From: Simon Davis
Sent: 29 January 2025 15:10
To: 'Dawn Appleton'
Cc: 'Peter Cleveland'
Subject: AL/137/24/RES Land Rear of Meadow Way

Our concerns with this application are set out per the following headings (as taken from the text of the refusal reasons):

CLIENT	SCALE	DATE	DRAWN
Redrow Homes Limited	1:1000 @ A3	JAN 2025	GW
DRAWING NUMBER	REVISION		
12083 TPP 01 Rev D (West)	D

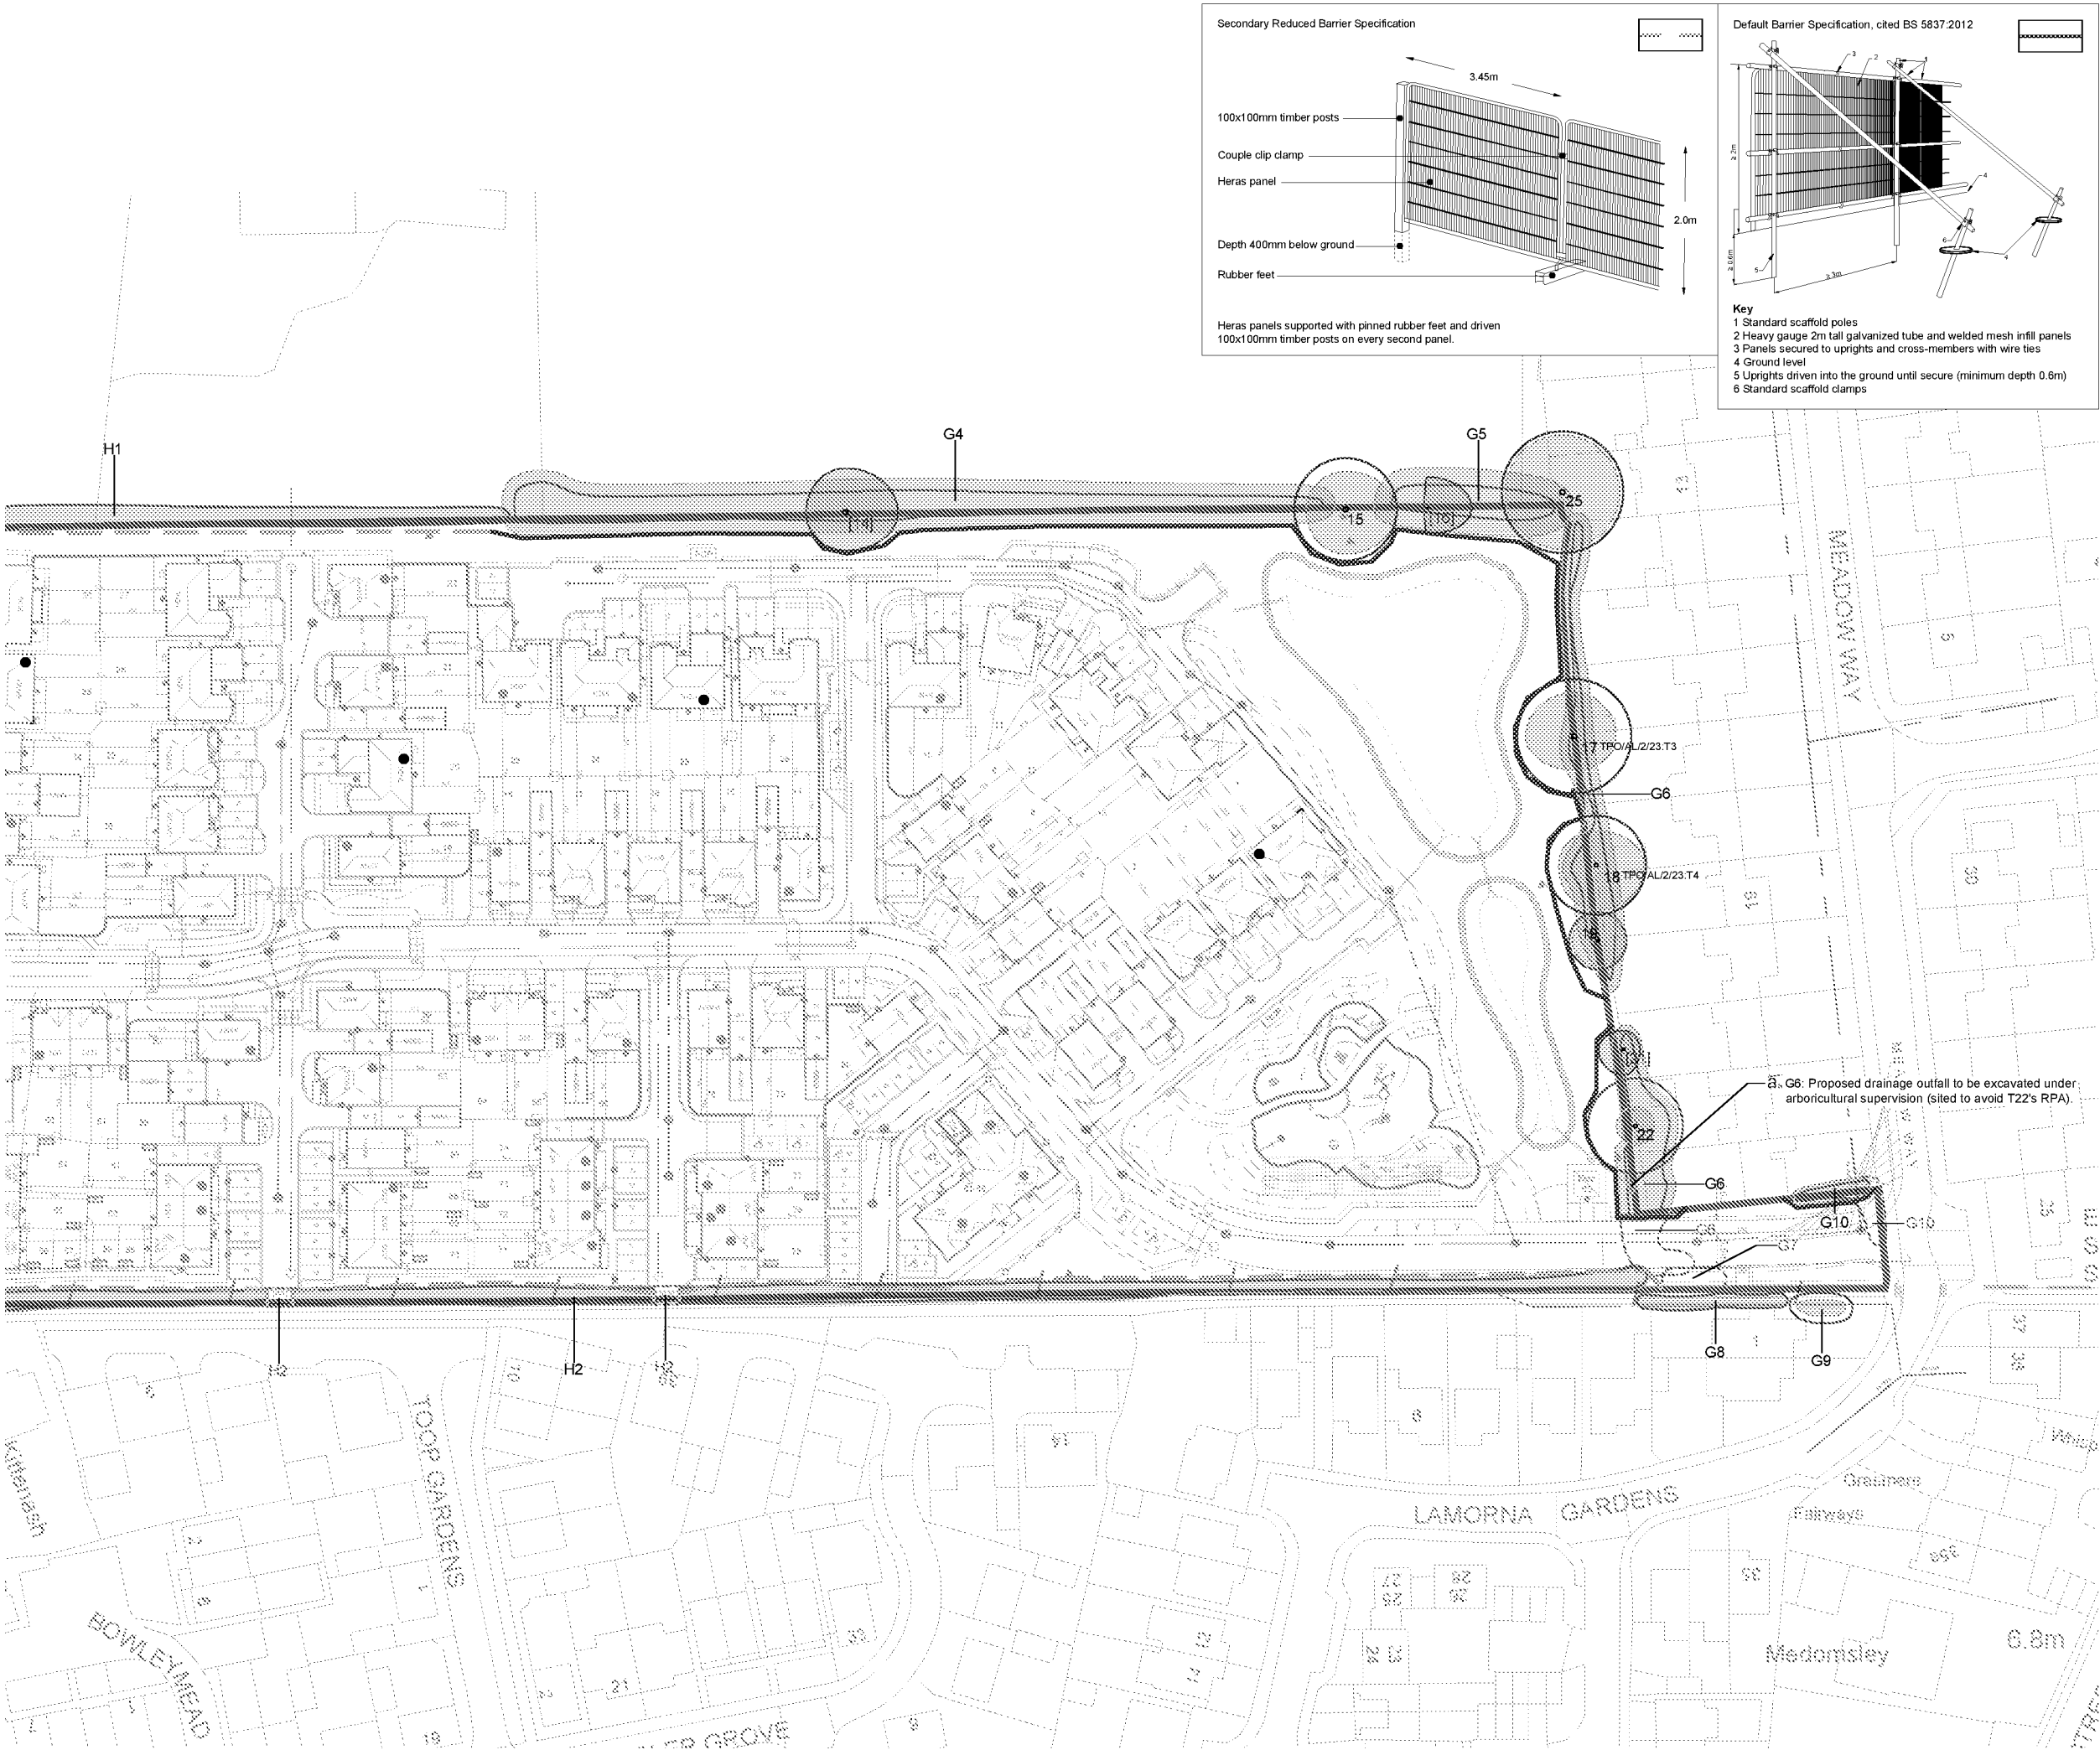
(2) The failure to ensure a sufficient off-set distance between important offsite trees and plots 38 & 46-48

The scheme has resolved the issue with plots 47 & 47, but concerns remain ref 39-46 (note we are awaiting Tree Officer comments).
